Planning Application Ref: WA/48/21/TC

Location: Walberton House, The Street, Walberton, BN18 0PJ

Description of works: Removal of 1no. ash (T1) because of ash dieback

Comments on Application:

Figure. 1 Ash (T1) Showing overhang of car-park

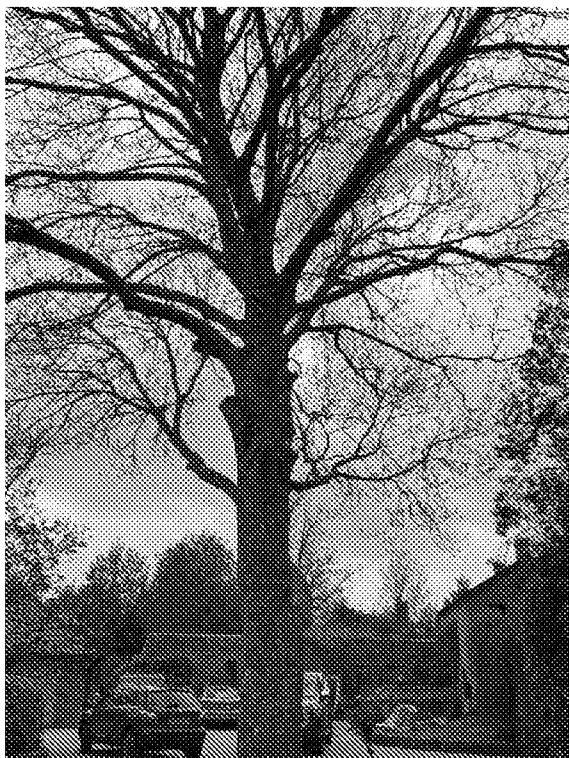
- The applicant is seeking to remove the tree on the grounds that it is diseased and likely to become hazardous. I did not observe any obvious symptoms of *Chalara* infection (ash dieback) - on the contrary, the tree appears to be in good condition. That is not to say the tree is not infected, but in the absence of clear evidence of significant disease we should proceed on the basis that it is healthy and may remain so.

- I did not see any large lesions on the scaffold limb framework, although a recently formed 'hazard beam' (longitudinal split) had opened on an east-tending limb low in the crown. Deadwood content did not appear obviously problematic or indicative of disease.

- It has not been satisfactorily demonstrated that this tree is or likely to become hazardous in the near future, as a consequence of *Chalara* (ash dieback) infection.
- The tree is an attractive feature in the local street-scene, contributes positively to the character of the area and appears to be in adequately sound and healthy condition.

- I recommend the making of a Tree Preservation Order to preserve its place in the landscape and better control its future management. I attach a TEMPO form and GIS plan for this purpose.
